# ENG-SF21010-R1-GEC-Redlines.pdf Markup Summary

SF-21-010

**POND C1 FOREBAY, LOW FLOW CHANNEL AND OUTLET STRUCTURE LAYOUT**

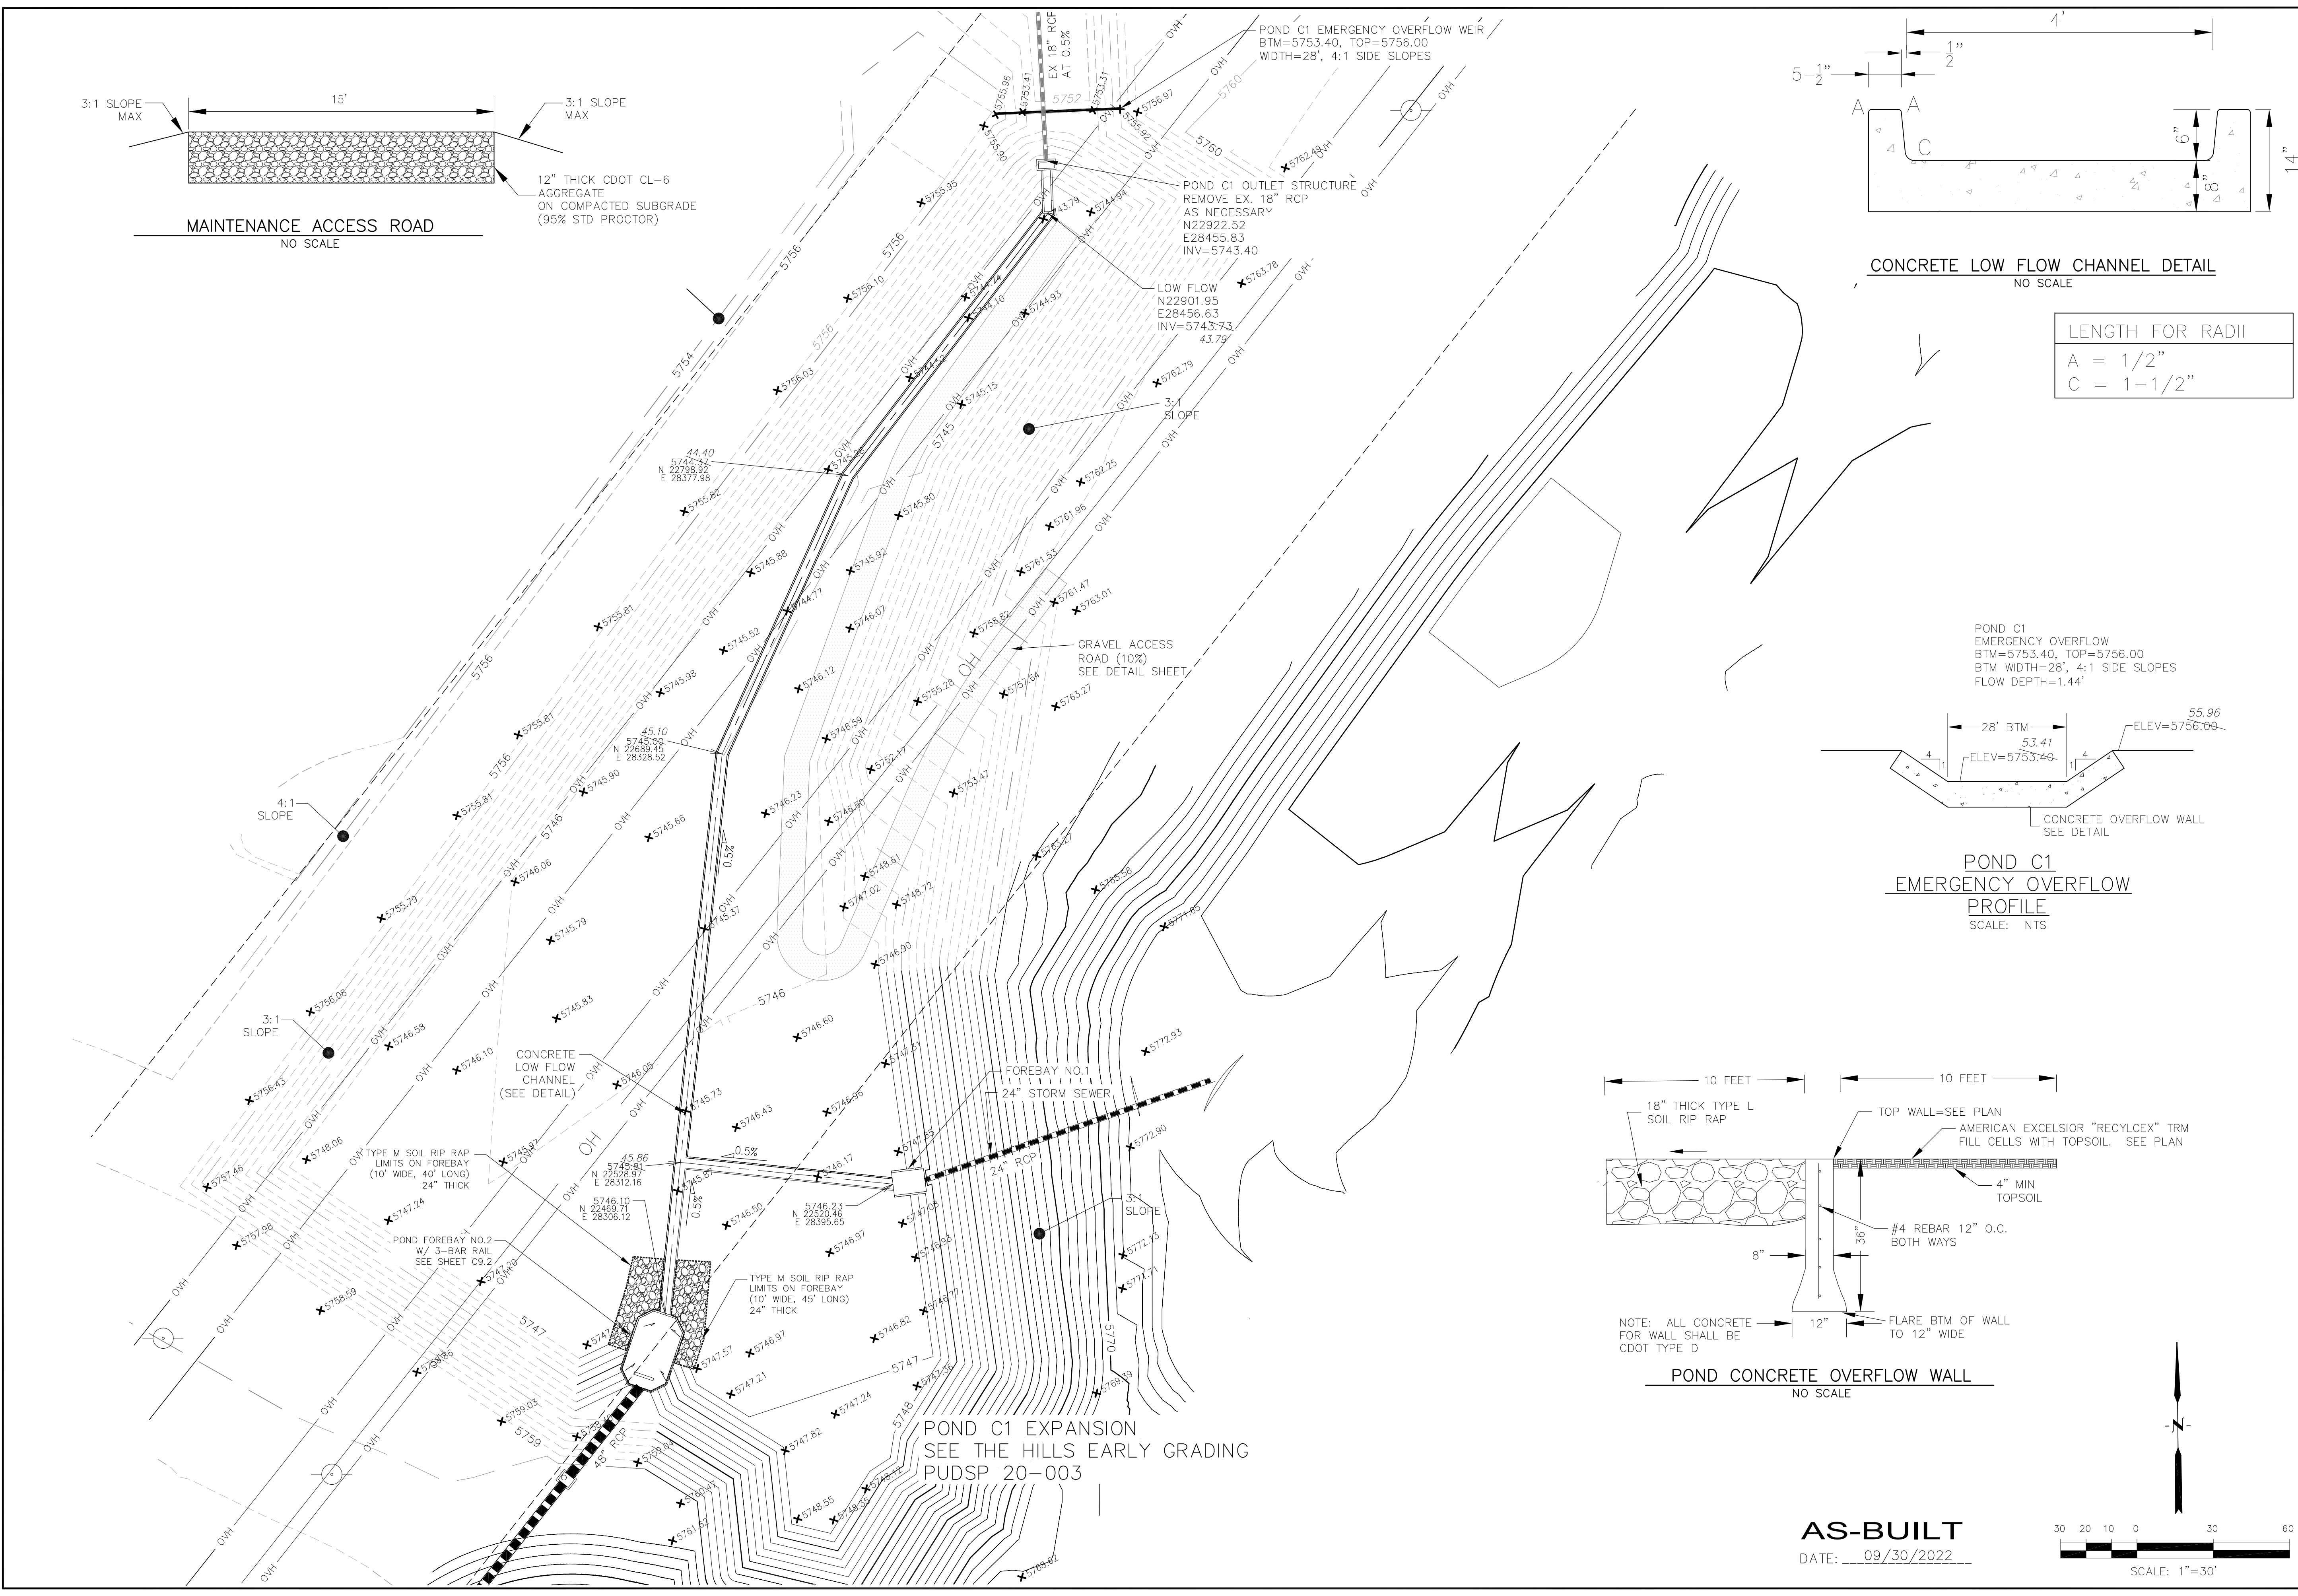
Show and label emergency spillway for Pond C1, as mentioned on FDR page 43 of 227.

Typical for all ponds.

Size per UD-Detention spreadsheet.
